DOC17/364949-03; EF13/3519

Department of Planning and Environment
GPO Box 39
SYDNEY NSW 2001

**EPA Assessment of Proposed Modifications to
Rix's Creek Open Cut Mine (DA 49/94 Mod 9) and Rix's Creek North (DA 08_0102 Mod 7)**

Figure 2 – Proposed exploration drilling location

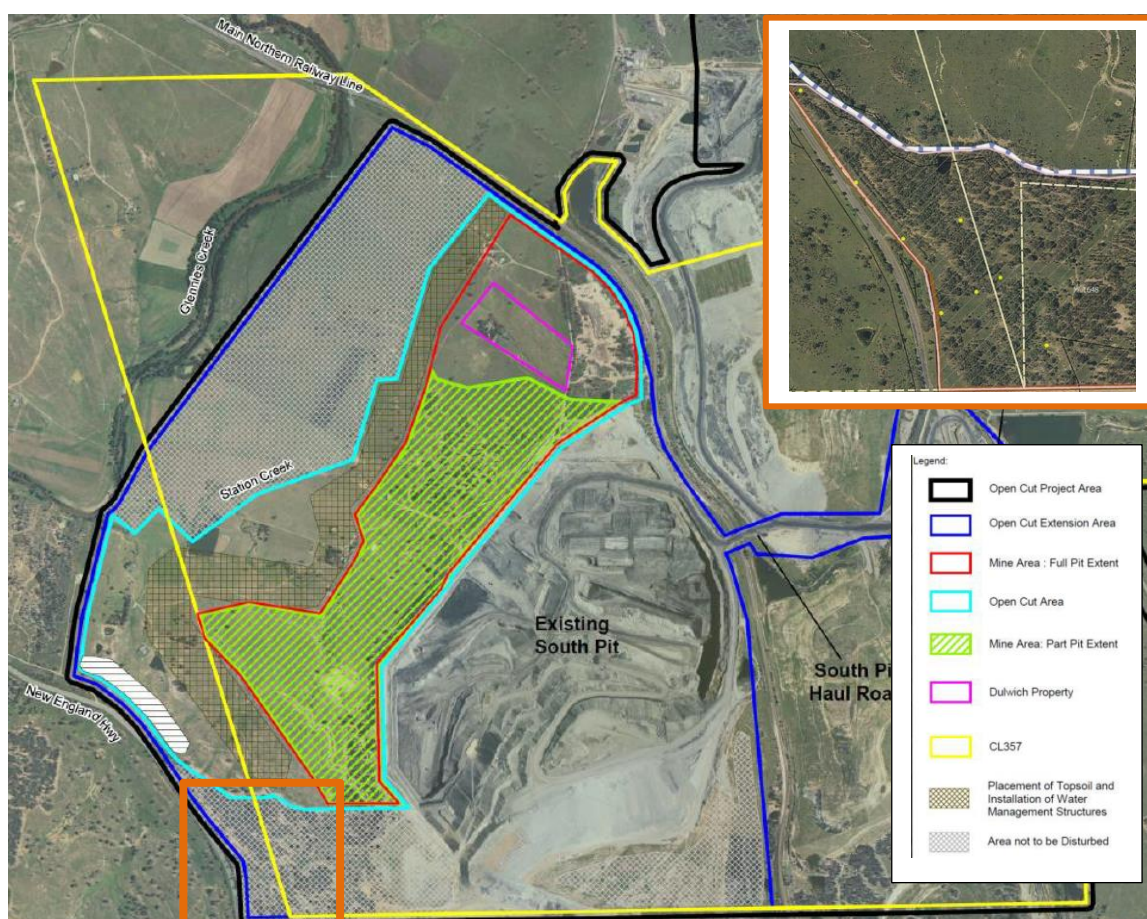
The EA is required to clearly identify if exploration drilling will occur within the licence boundary applicable for Rix's Creek Coal Mine, Environment Protection Licence 3391, or outside of the licence boundary. The proponent needs to identify the current licence boundary to Figure 2 to enable the EPA to provide appropriate advice.
